1 December 2014

RE: Modification Request for the Botany Industrial Park – DA 30/98 MOD 2

The Council has received notification from the Department regarding the above mentioned modification application. The proposed modification involves amendments to the internal allotment boundaries and updating the existing conditions of consent to reflect current legislation and environmental management and reporting requirements.

G:\Projects\603 Projects\60322972 Orical\FIGURES\60322972 F4 Proposed Amendments to Subdivision 18.06.2014 TO Rev B

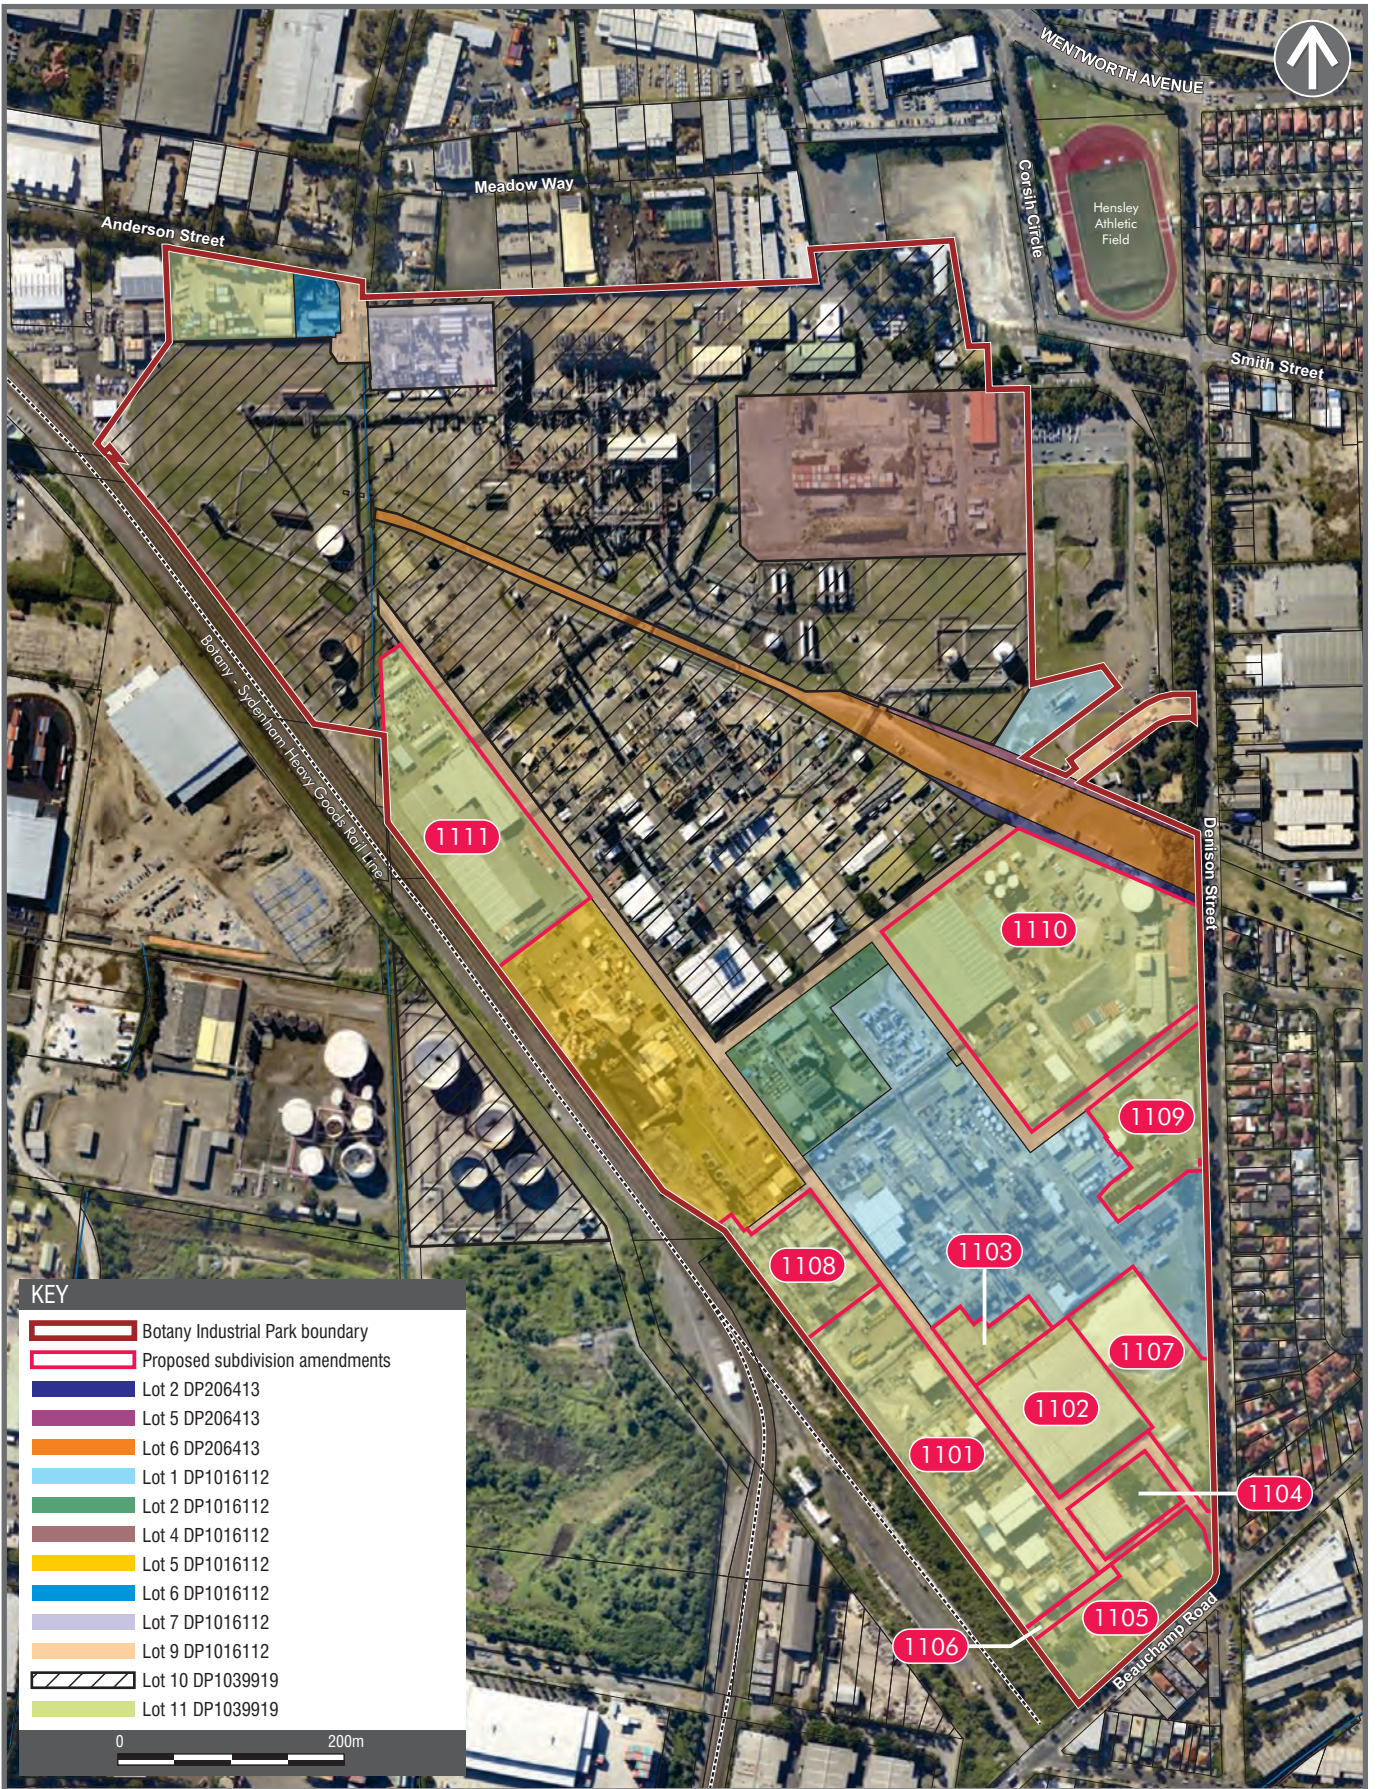
- Lot 11 DP 1039919 consist of seven existing parcels of lands, not six parcels as referred in the Section 75W Modification of Assessment prepared by AECOM dated 14 August 2014. Clarification (i.e. current/intended use and rationale) is required for the parcel located on the north-western corner of the Botany Industrial Park (fronting Anderson Street).
